2024/0949

51A Huddersfield Road, Barnsley, S75 1DR

Alterations to roof and conversion of loft into habitable space and erection of front porch.

Refusal

PROPOSED FRONT ELEVATION SCALE 1:100

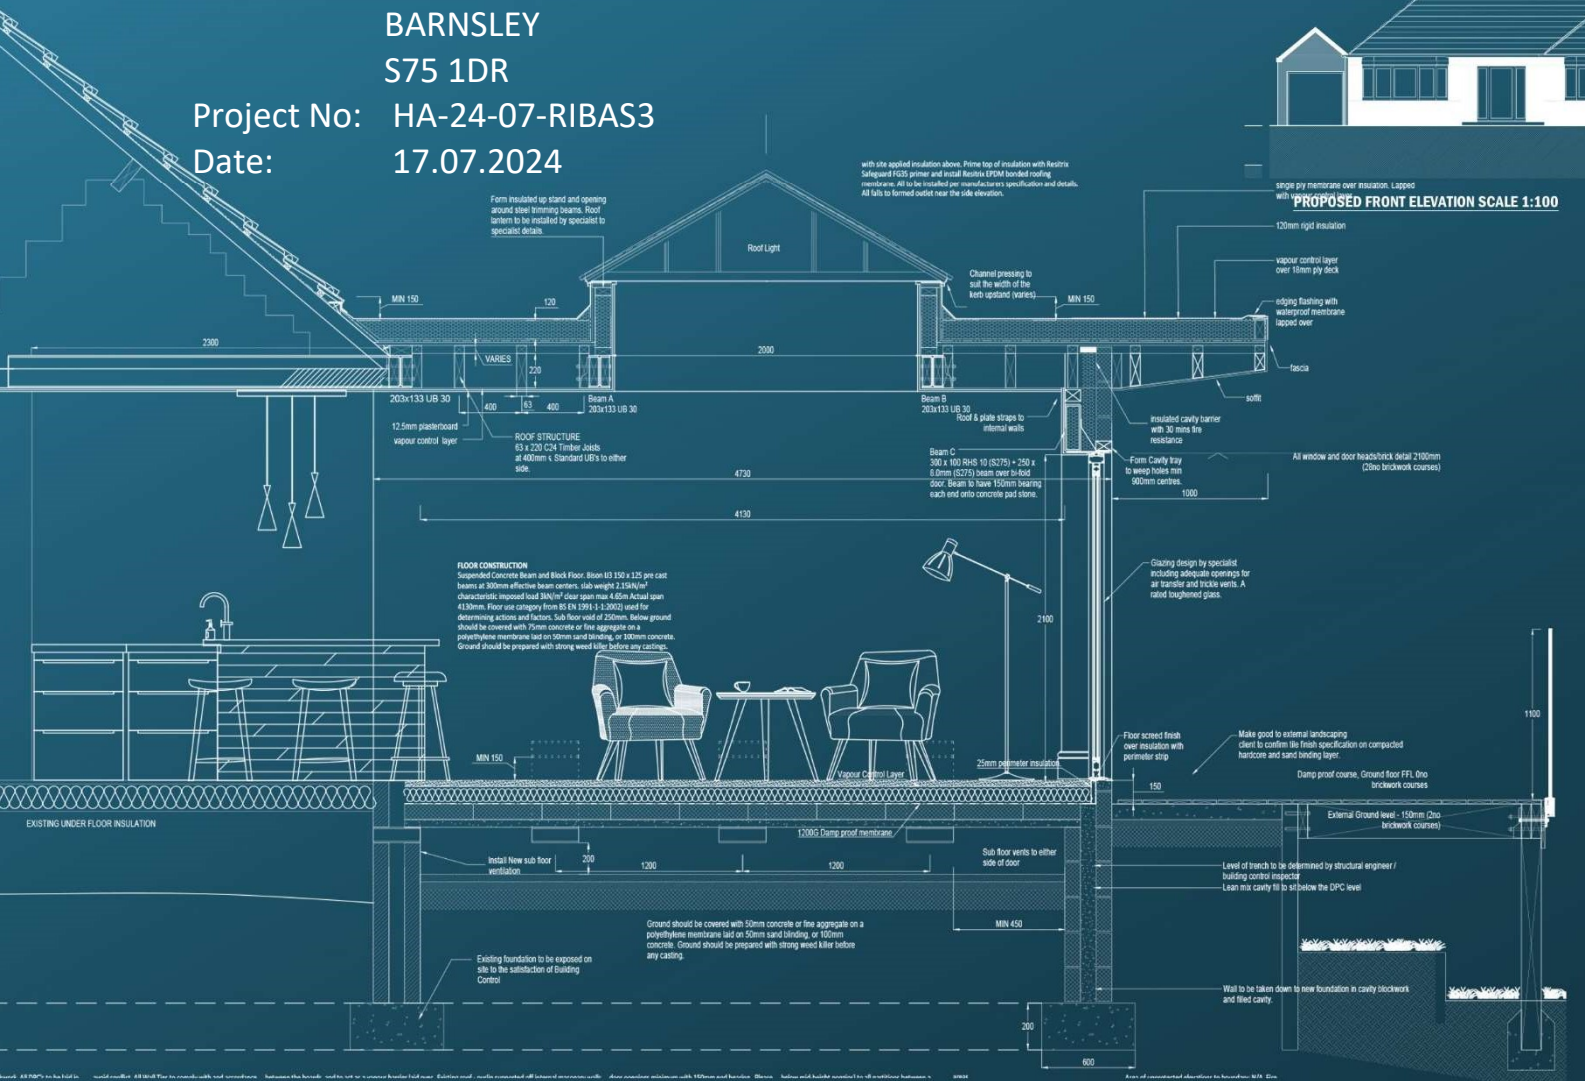
The change in roof form and erection of a porch would detrimentally alter the character of the dwelling and the character of the street scene. The dwelling possesses a strong symmetrical design; to change the roof form would drastically reduce the symmetry of the building as well as posing a loss to the historic appearance of the building and does not preserve or enhance the character of the Conservation Area.

The low-level asymmetry of the dwelling through the erection of the existing side extension is acknowledged, however this does not warrant the implementation of further asymmetry to the building. Although gable roof forms are evident within the area, the symmetry of the dwelling would be drastically altered, a change which is not common within the Conservation Area and should be avoided.

The proposed porch would provide an external floorspace of approximately 2.7 square metres which is below the 3 square metres allowed under permitted development. The proposed height of approximately 3.5 metres would exceed the 3-metre height permitted under permitted development. Whilst the height of the porch exceeds the parameters of permitted development, it is considered that the porch alone would not detract from the symmetry of the dwelling and would be considered acceptable. Nevertheless, this does not warrant the approval of a scheme which overall would have a detrimental impact on the character of the Conservation Area as outlined above.

Whilst the proposal is considered acceptable with regards to highways and residential amenity which carry modest weight in favour, the proposal is considered to be an unsympathetic asymmetrical addition to the street scene within a Conservation Area. The proposed roof alterations combined with the porch would detrimentally affect the symmetry of a building within the conservation area, negatively impacting the visual amenity of the dwelling and the character of the Conservation Area. The modest aspects in favour of the proposal are not considered sufficient to outweigh the significant negative weight against the proposal caused by harm to the conservation area as it would not preserve or enhance the character of the Conservation Area as required by the The Planning (Listed Buildings and Conservation Areas) Act 1990.
